Rezoning Transportation Analysis

Petition Number: 2020-197

Reviewer: Kevin Parker, PE
Kevin.Parker@charlottenc.gov
704-432-6511

Date	Description
12-28-2020	First Review (KP)
01-21-2021	Second Review (KP)
02-12-2021	Third Review (KP)

Pinecrest West

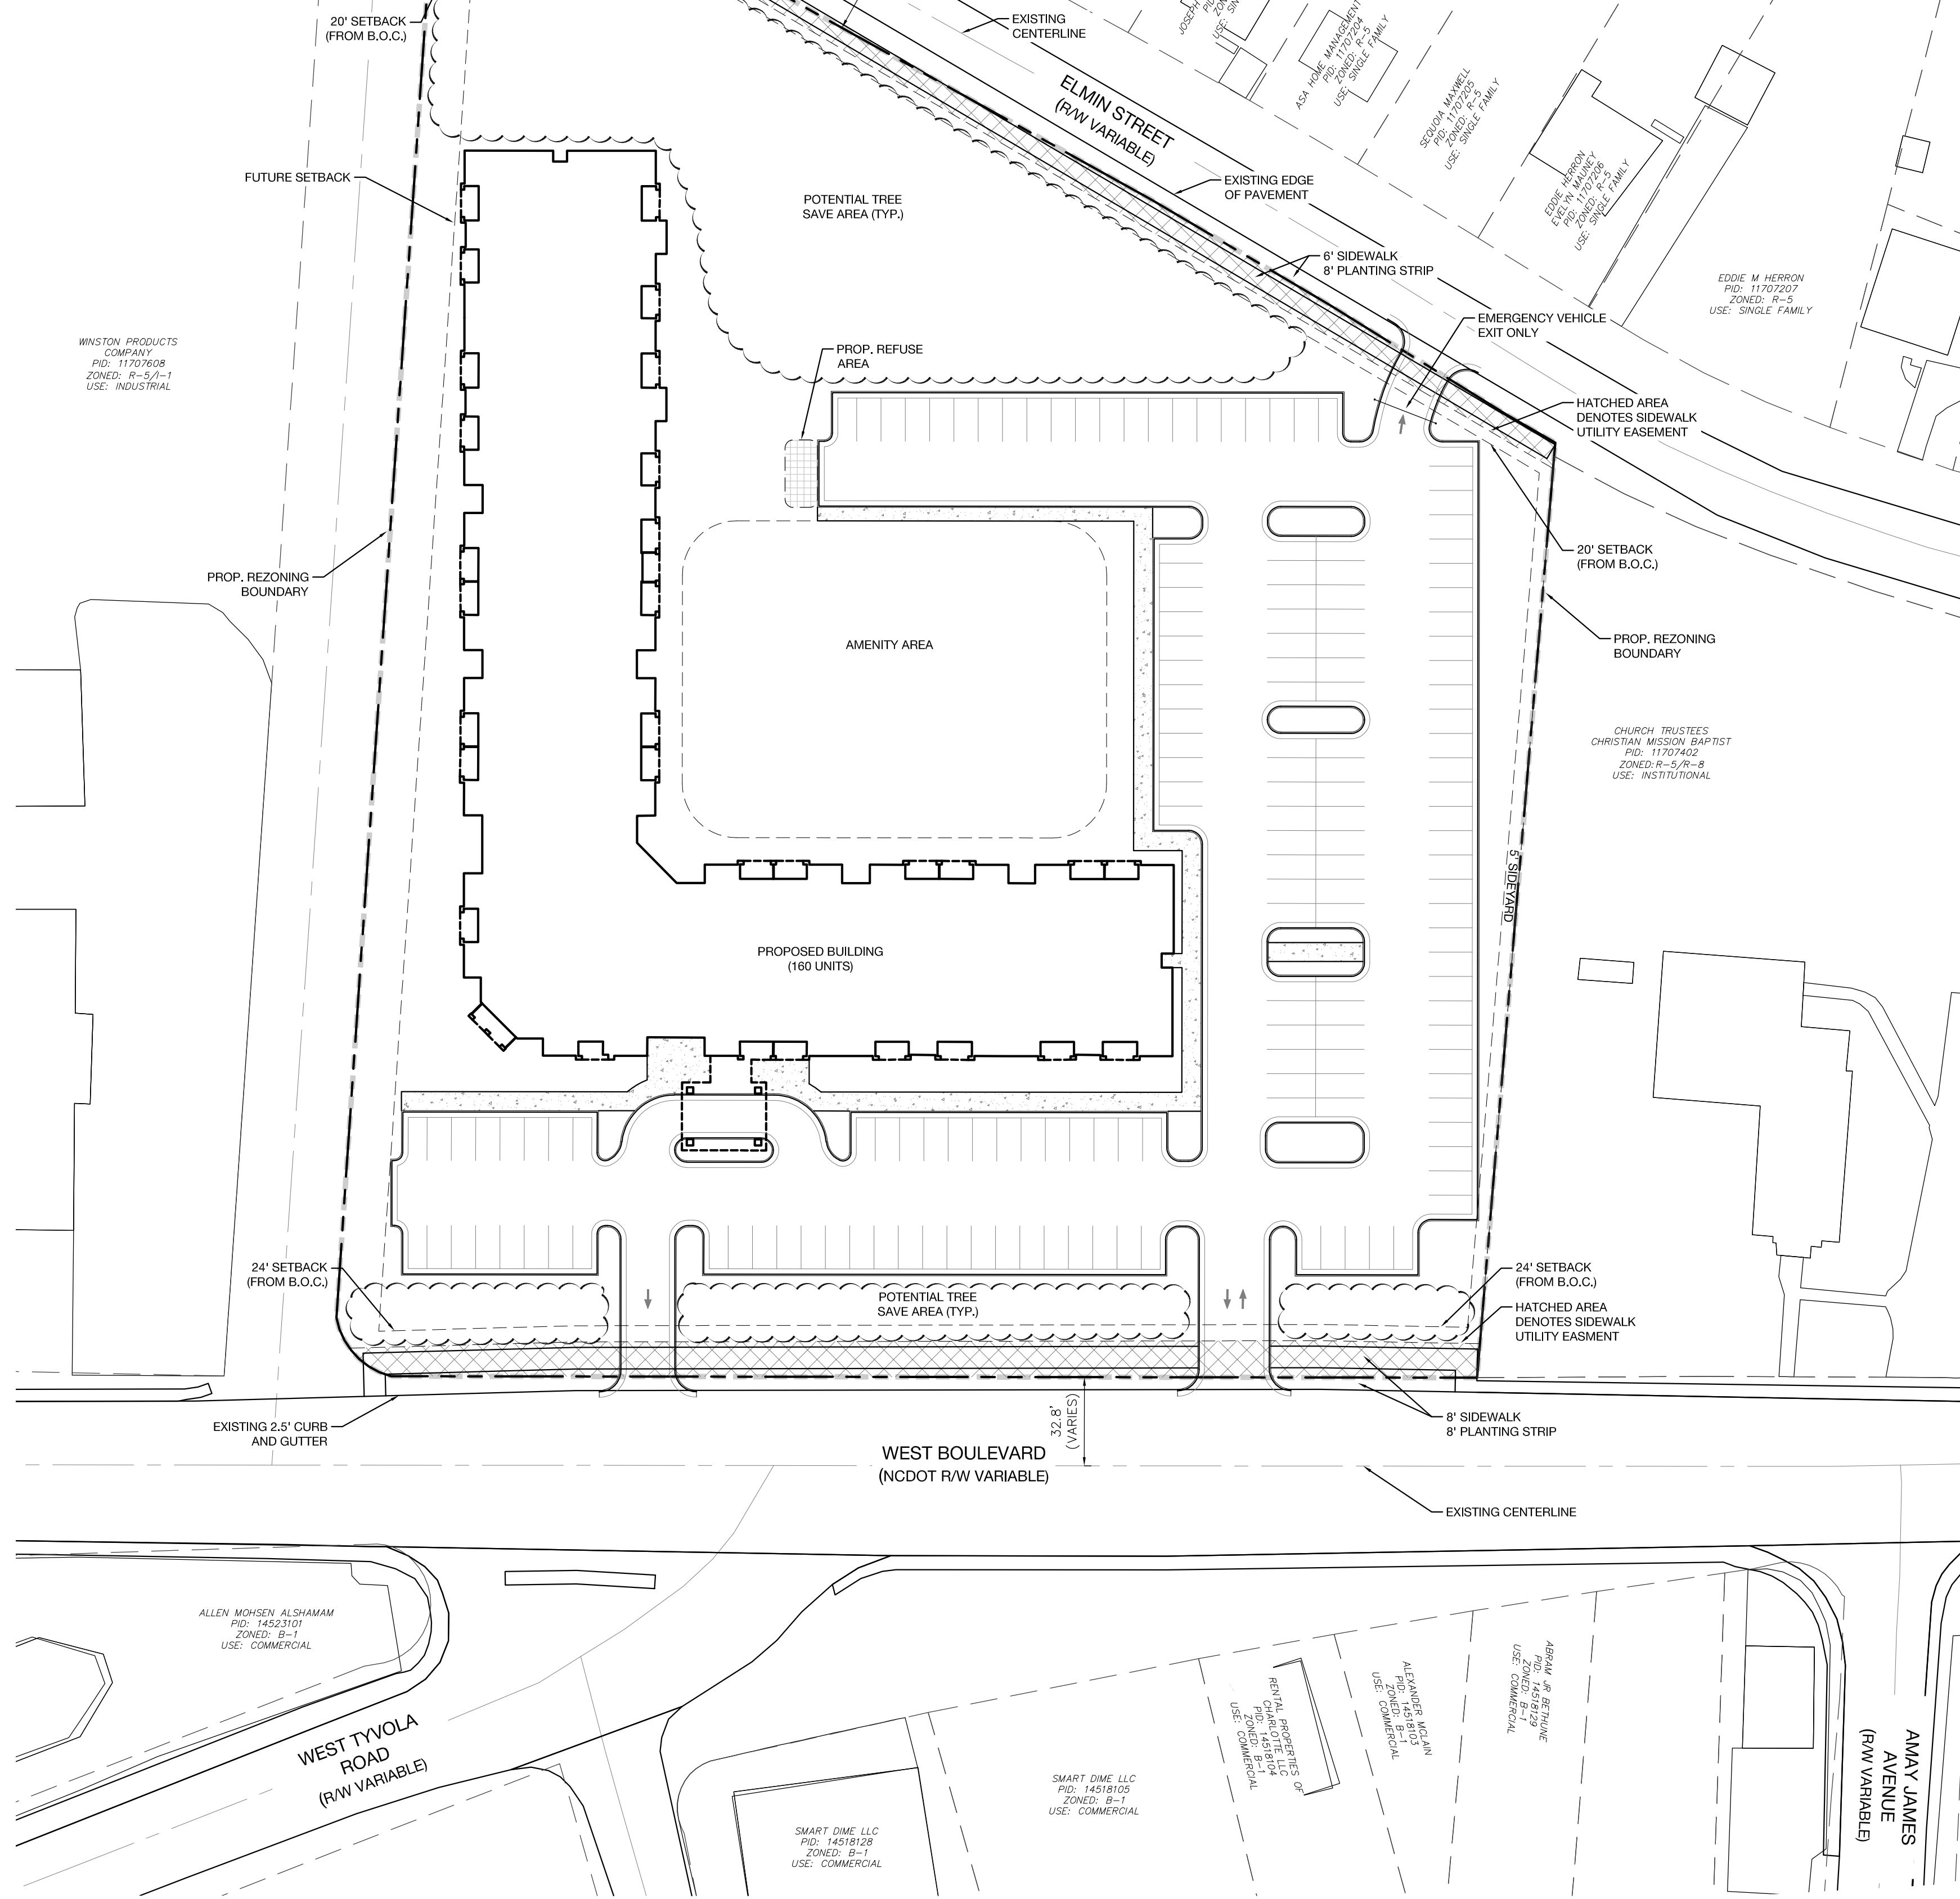
- a. ~~**West Boulevard:** The future location of curb and gutter will be 38-feet from centerline to back of curb to accommodate a future 4-lane Avenue with separated bike lanes.~~
- b. ~~**Elmin Street:** Location of curb and gutter will need to be constructed 17.5-feet from the centerline to back of curb, according to the City's Local Residential Wide (U-03A) street section.~~
~~Meeting on 01/07/2020 - Changed Elmin curb line to 13-feet to BOC, which reflects the city's local residential medium section.~~

- a. ~~**West Boulevard:** Revise site plan and conditional note(s) to commit to dedicate 54-feet of right-of-way from the road centerline.~~
- b. ~~**Elmin Street:** Revise the site plan and conditional notes to commit to dedicate 35.5-feet from the road centerline, in accordance with the City's Local Residential Wide (U-03A) street section.~~
~~Meeting on 01/07/2020 - Changed Elmin ROW to reflect the city's local residential medium section.~~
- c. ~~**Paper Right-of-way:** Revise the site plan and conditional notes to dedicate 28-feet of right-of-way from the existing paper right-of-way centerline, in accordance with the City's Local Residential Medium (U-02) street section.~~
~~Update as a result of the 01-12-2021 resubmittal: Minimum ROW dedication was provided.~~

- 4. ~~Revise site plan and conditional note(s) to commit to construct a 16-foot planting strip and 8-foot sidewalk along the site's frontage of West Boulevard, to accommodate for a future buffered bike lane,~~

and an 8-foot planting strip and 6-foot sidewalk along Elmin Street and the developed portion of paper right-of-way. Label and dimension both items from the back of curb and gutter and road centerline.

6. ~~Revise the site plan by including the existing infrastructure and striping for the center median and turn lane on West Boulevard and the channelized island at West Tyvola and West Boulevard.~~

7. ~~Revise the site plan by creating a full movement (ingress and egress) driveway onto/from Elmin Street.~~

8. ~~Revise the site plan and conditional notes by committing to constructing a curb ramp, in accordance with NCDOT Standards, at the corner of West Boulevard and the existing paper right-of-way adjacent to the site.~~

9. ~~Revise site plan and conditional notes by removing the proposed driveways on West Boulevard and developing a portion of the existing paper right-of-way to provide access into the site. Additionally, the driveway at the paper right-of-way and West Boulevard will be a right-in right-out movement which will necessitate the extension of the existing center-lane median on West Boulevard, in accordance with NCDOT Standards. Lastly, the portion of developed paper right-of-way will be developed to the City's Local Residential Medium Section (U-02) and will include an 8-foot planting strip and 6-foot sidewalk along the east side (the site's frontage) of the developed paper right-of-way. This will also include a dead-end street barricade and marker in-line with CLDSM, at the street stub. The site plan should label and dimension each item from the road centerline.~~

10. ~~Revise the site plan and conditional notes by committing to coordinate with CATS, during permitting, to make improvements to the existing bus stop on West Boulevard. The site plan needs to show the existing bus stop.~~

11. ~~The site is located on a block length of 2,619 feet (see below blue line), from Old Steele Creek Road to Elmin Street. The proposed site's paper street is located approximately 1330 feet to the west of intersection of Old Steele Creek Road and West Boulevard. Since the UR-2 zoning district is being requested under this petition, please address Outstanding Issues 5 and 9, to promote walkability and connectivity, per the Urban Street Design Guidelines.~~

15. ~~New comment as a result of the 01-12-2021 Site Plan resubmittal: Revise the site plan and conditional notes by including an 8-foot dimension on the sidewalk constructed in the paper ROW. Additionally, locate the back of the 8-foot sidewalk 29-feet from the centerline of the paper ROW, in accordance to the City's Local Residential Medium Section. Additionally, place a sidewalk utility easement 2-feet behind the back of sidewalk where feasible.~~

16. ~~New comment as a result of the 01-12-2021 Site Plan resubmittal: Revise the site plan to extend the 8-foot sidewalk and planting strip, along West Boulevard, through the paper right-of-way and tie the sidewalk into the existing curb ramp on the west side of the paper right-of-way.~~

17. ~~New comment as a result of the 01-12-2021 Site Plan resubmittal: Revise the site plan by adding a curb ramp, on the south side of Elmin Street, at the corner of Moreland Street and Elmin Street. Additionally, revise the site plan by committing to bringing the existing curb ramp on the north side of Elmin Street to CLDSM standards.~~

18. New comment as a result of the 01-12-2021 Site Plan resubmittal: Revise the site plan to extend the 8-foot sidewalk and planting strip, along Elmin Street, to the west boundary of the paper right-of-way.

19. New comment as a result of the 01-12-2021 Site Plan resubmittal: Remove conditional note 3.E. No portion of this right-of-way will be abandoned.

~~**Update to comment as a result of the 01-12-2021 Site Plan resubmittal:** Petitioner has dedicated ROW, in-line with the City's local residential medium section and included a sidewalk (width not yet clarified) within this paper ROW.~~

~~**01/27/2021 - Comment resolved.** Stormwater issues deterred the access drive off the paper ROW, but the ROW dedication and sidewalk installation for/in this paper ROW is an acceptable trade-off.~~

~~**Update to comment as a result of the 01-12-2021 Site Plan resubmittal:** Petitioner has dedicated ROW, in-line with the City's local residential medium section, and included a sidewalk (width not yet clarified) within this paper ROW.~~

~~**Comment Resolved:** The petitioner has agreed to construct an 8-foot wide sidewalk, within this paper ROW, in relative to CLDSM Local Residential Medium Section.~~
